January 29, 2018

Subject: TimberRidge Planned Unit Development (PUD-17-003) **Review 4**
Application has been redesigned with this review.

The purpose of this letter is to provide you with a response to staff and agency comments found in your letter of January 9, 2018. Responses to comments are shown in **RED** below the comment.

PHASE MAP

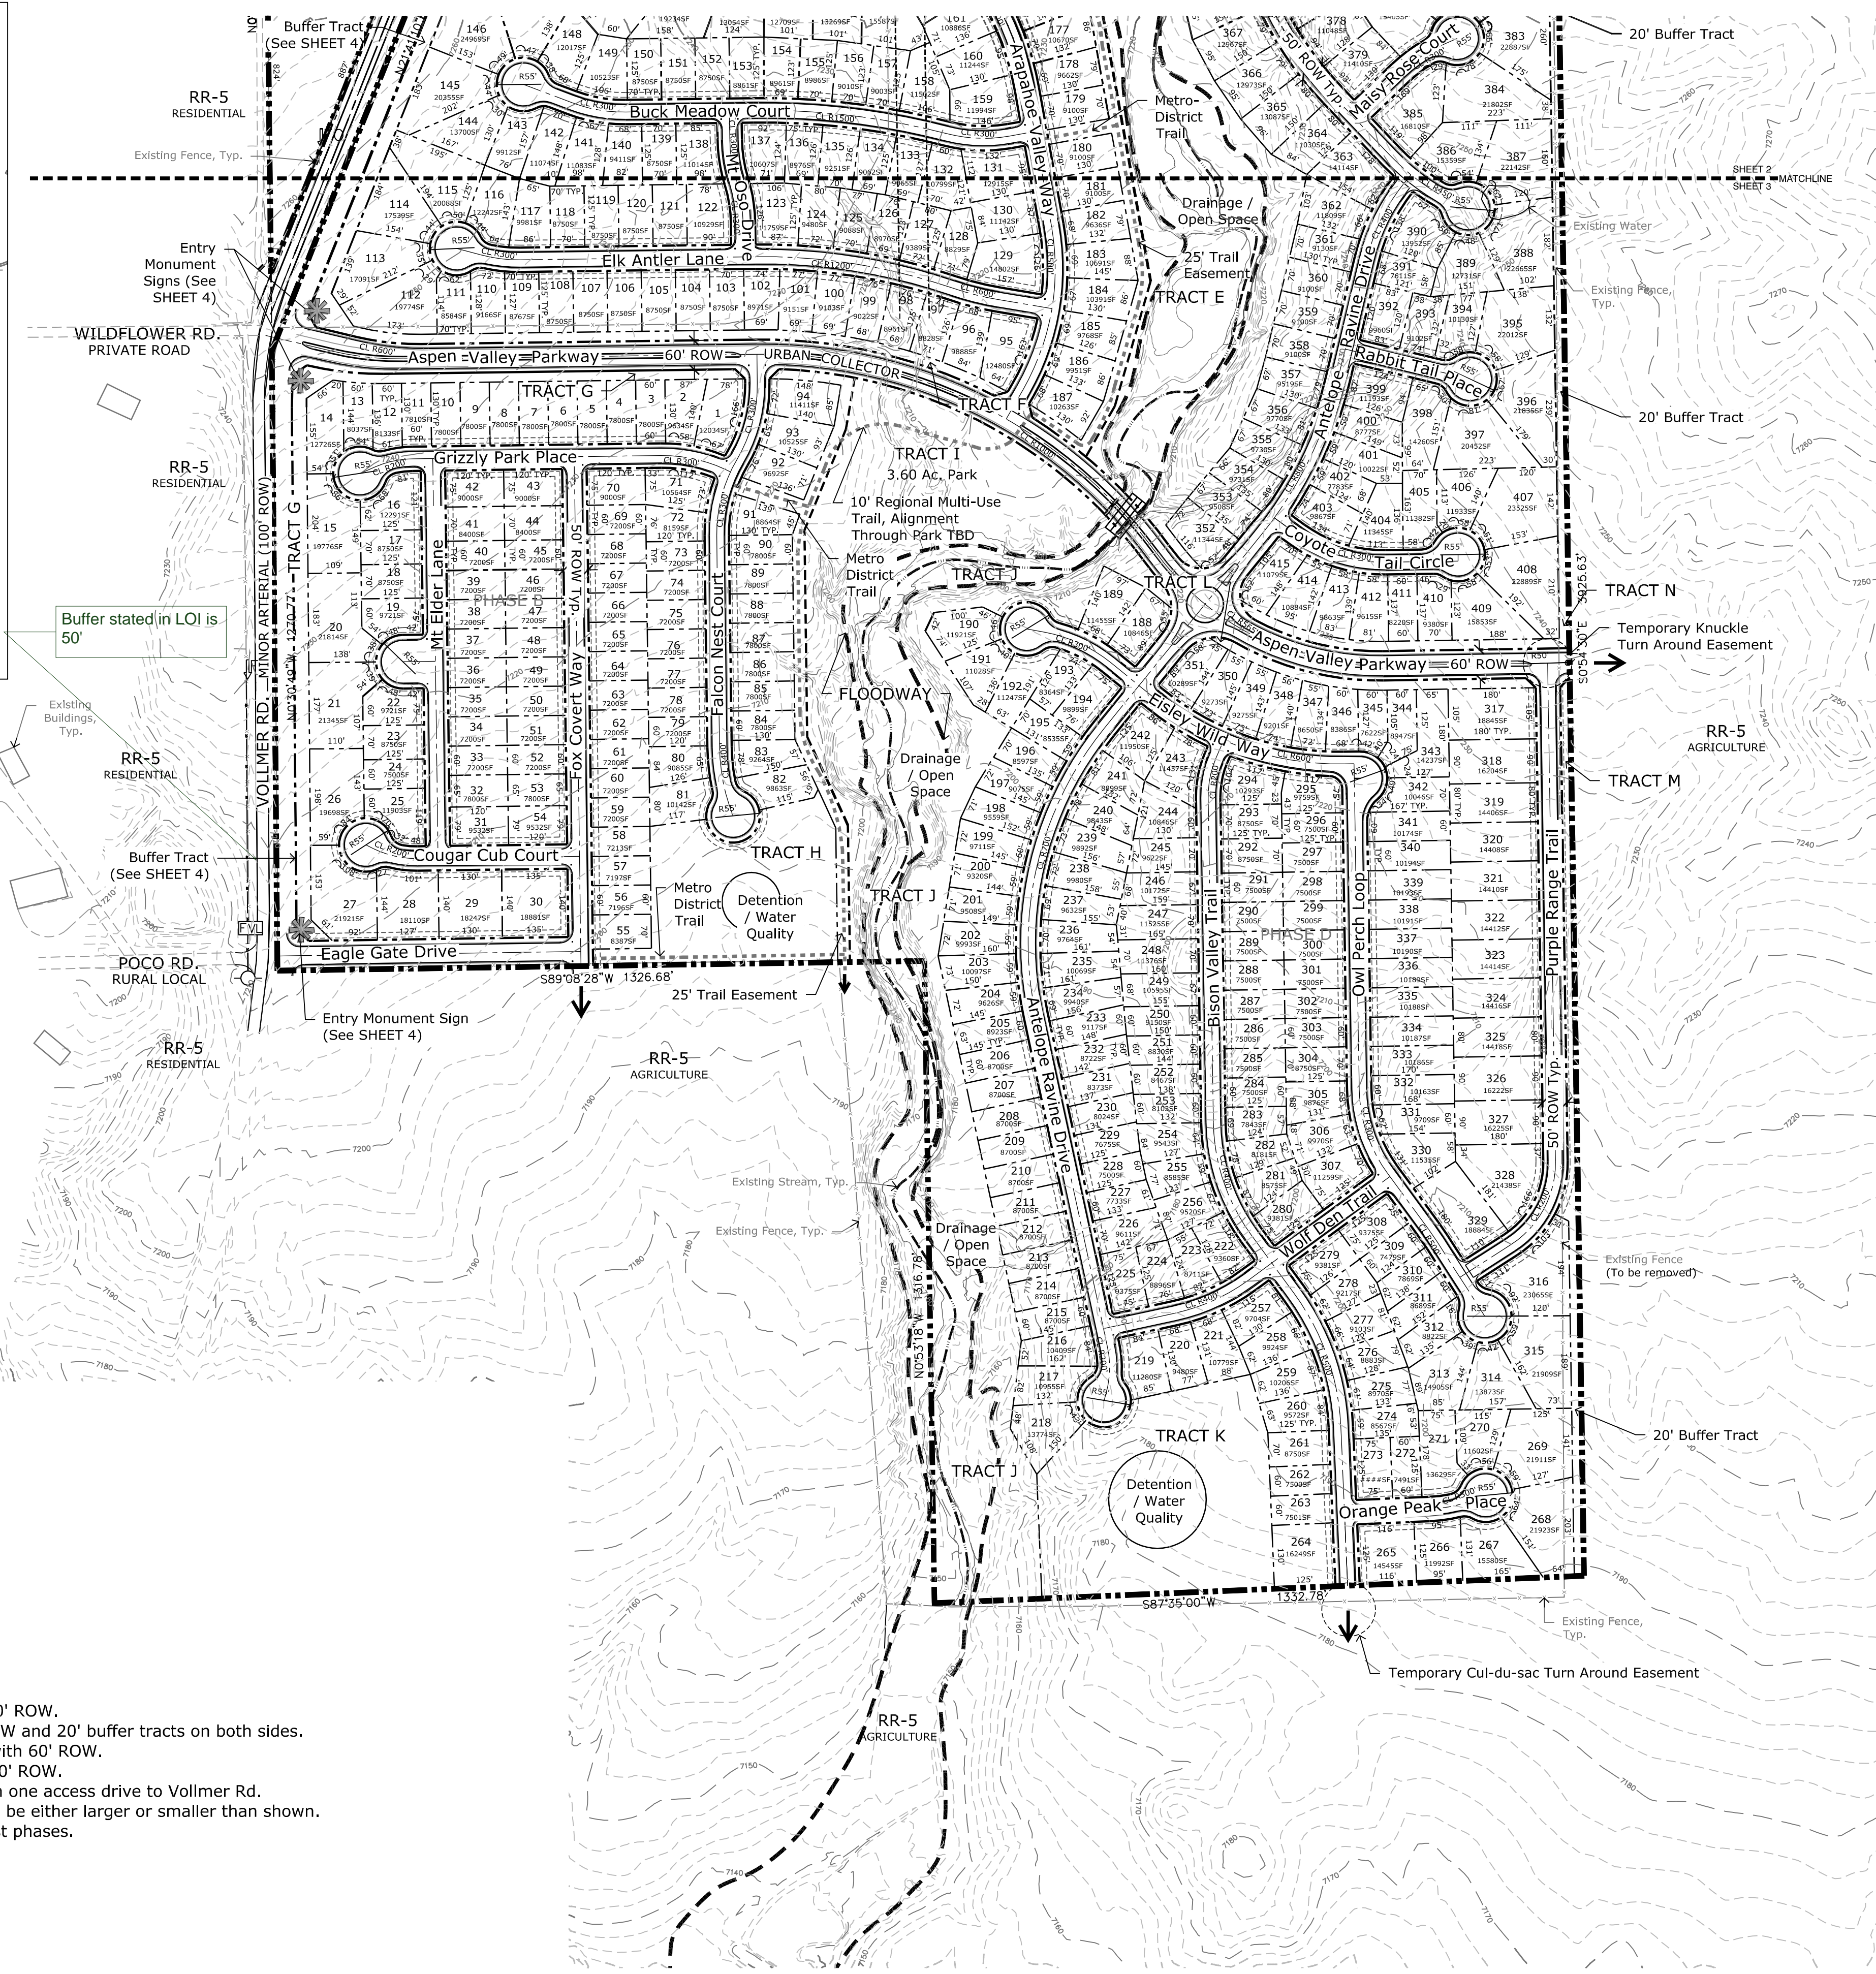
- 3. Phasing Plan was not uploaded. Please address the phasing and include phasing of the open space. Number of preliminary plans and locations should be included. It may be logical to establish a well and on-site sanitary lot preliminary plan verses a central service provider to lots preliminary plan. A separate Phasing Plan drawing has been uploaded.**

OVERALL LANDSCAPE PLAN

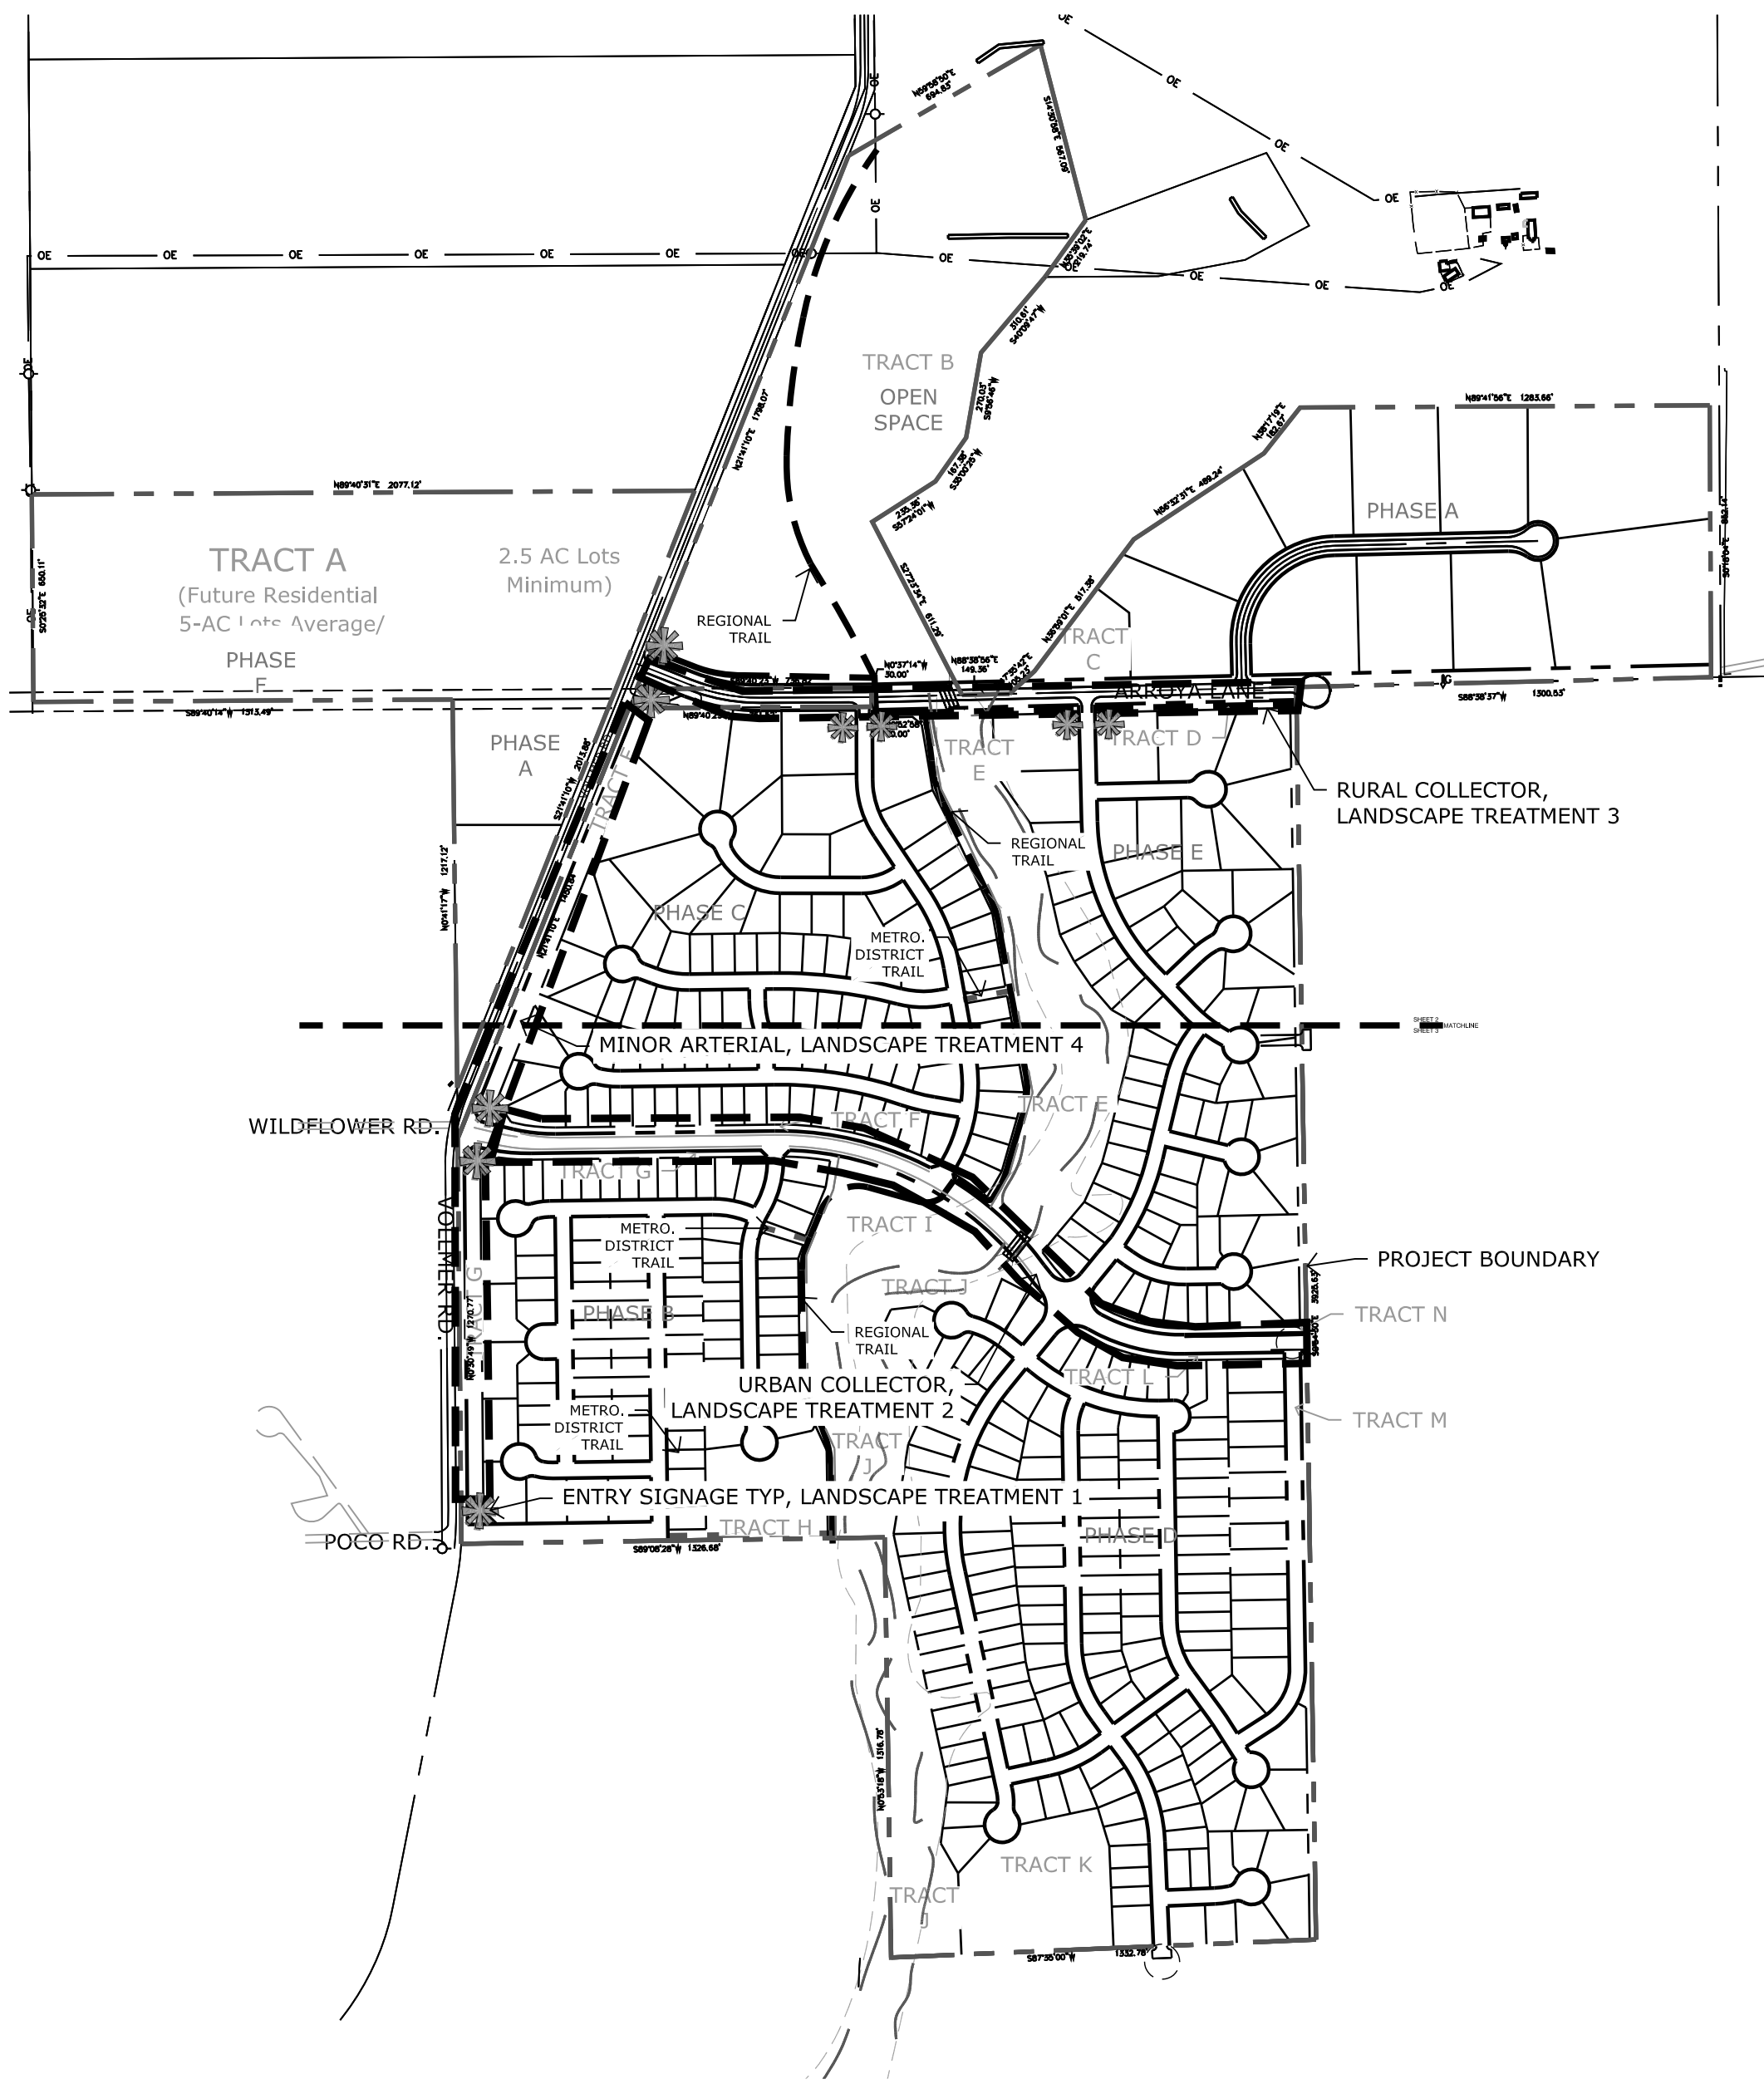
7. **Note the boundary and parcel numbers on the Wildfire Hazard Mitigation Map Please. The boundary includes land not included; however, analysis outside of the proposed PUD does not impact the study. No change needed to document. Noted.**
8. **The landscape plan uploaded is not a landscape plan but rather a land suitability analysis. Please upload the landscape plan for Vollmer Road and Arroya (a roadway classified greater than a local residential). A PUD modification is required if no landscape is proposed. Further noted in red lines. A Landscape Plan has been added to the PUD Plan as Sheet 4.**
9. **The open space requirements have not been met; a PUD modification is required. Further noted in red lines. Based on the calculations below, the open space requirement is met.**

Calculation of Open Space. The TimberRidge PUD has 19.8 acres of open space within the Sand Creek Greenway. In addition, 1 acre of open space is within three tracts along Arroya Lane, and 10% of the requirement is permitted to be in drainage tracts or 2.6 acres. There are 4.05 acres of open space in water quality tracts. The PUD regulations for TimberRidge require a 100 foot setback along a significant portion of Vollmer Road, essentially creating a public open space/visual corridor along the road. This area totals 4.4 acres in size and is permitted by Code (2.2.6(E) (8) (c), which states “...private residential ...lot areas shall not be included in open space calculation unless the open space areas located on private lots are subject to open space...restrictions.” The total amount of open space is therefore 27.6 acres or 10.5% of the entire PUD. (19.6 + 1.0 + 2.6 + 4.4 = 27.6 acres of open space)
